Please ask for: Ms Iqraa Malik
Email: iqraa.malik@terraquest.co.uk
Telephone: 01212341390
Our Ref: FG/28/21/HH
Your Ref:
Date: 23rd February 2021

Application for Planning Permission for Works or Extension to a Dwelling

Development: Single storey rear extension with pitched roof and side conservatory
Location: 3 Hermione Close Ferring BN12 6PZ

Existing Floor Plan

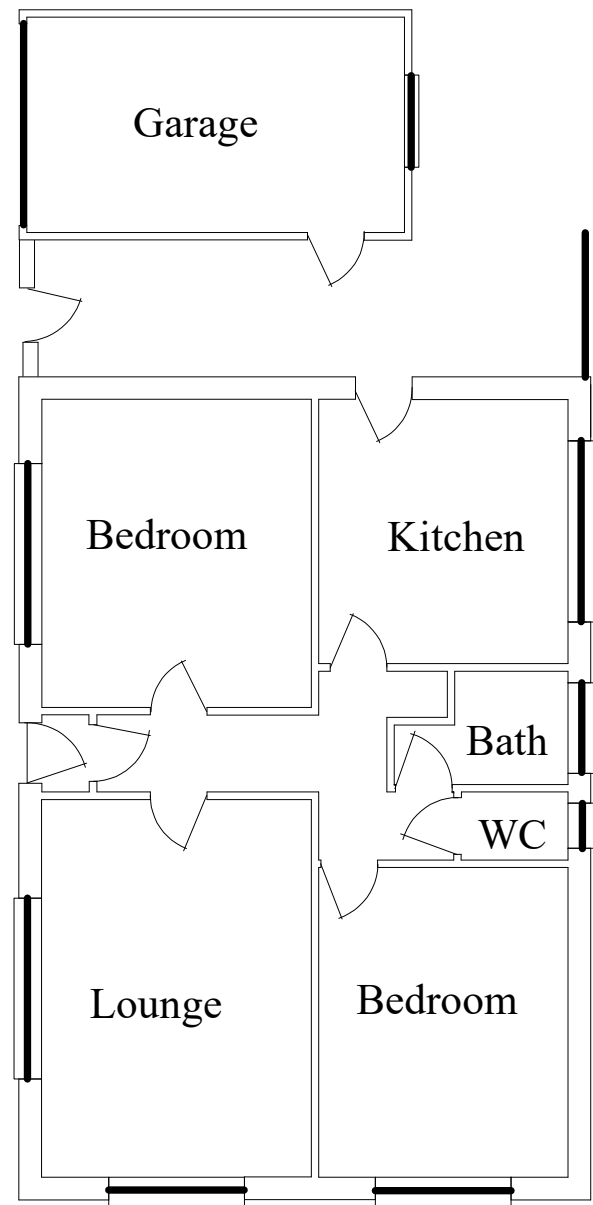
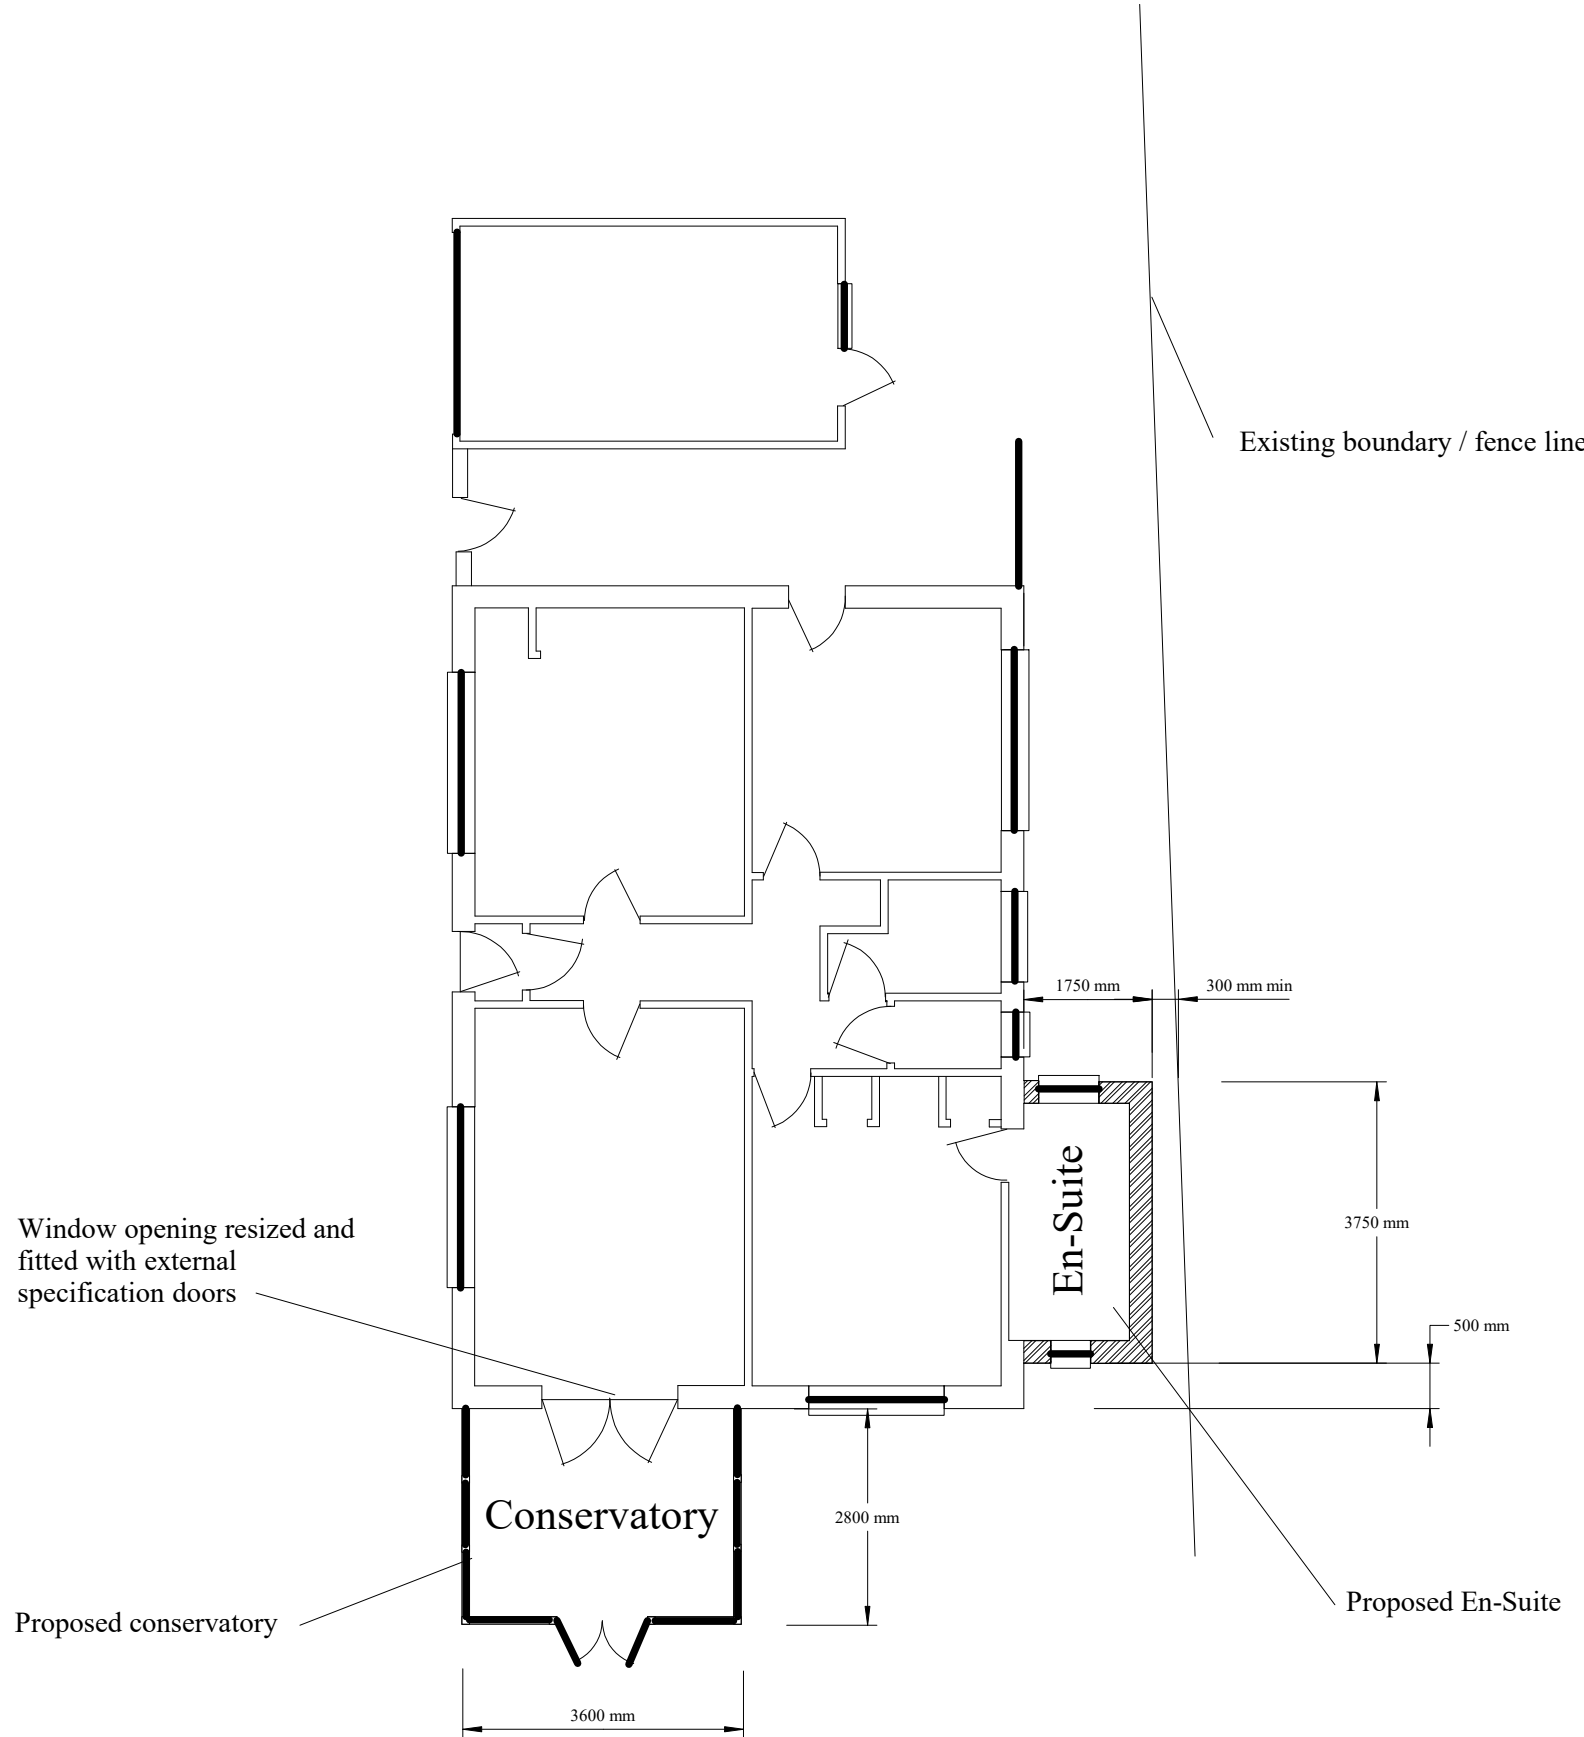
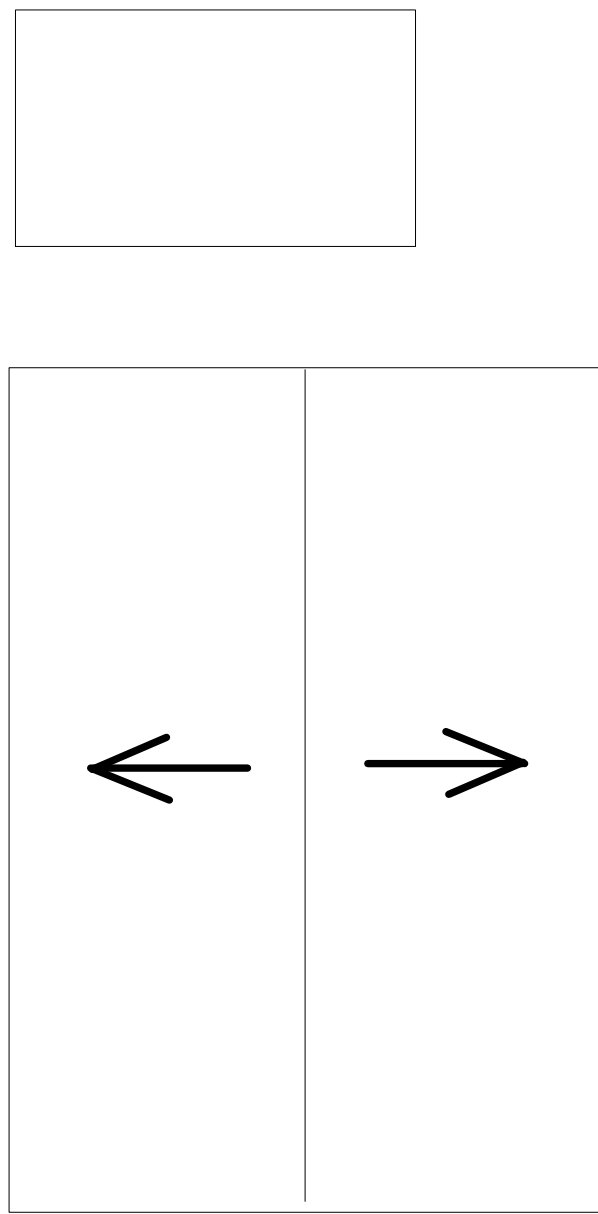
The garage doors on the existing front and rear elevations are not consistent with the existing floor plans. Please review and amend accordingly.

Please provide a scale bar on the existing and proposed plans.
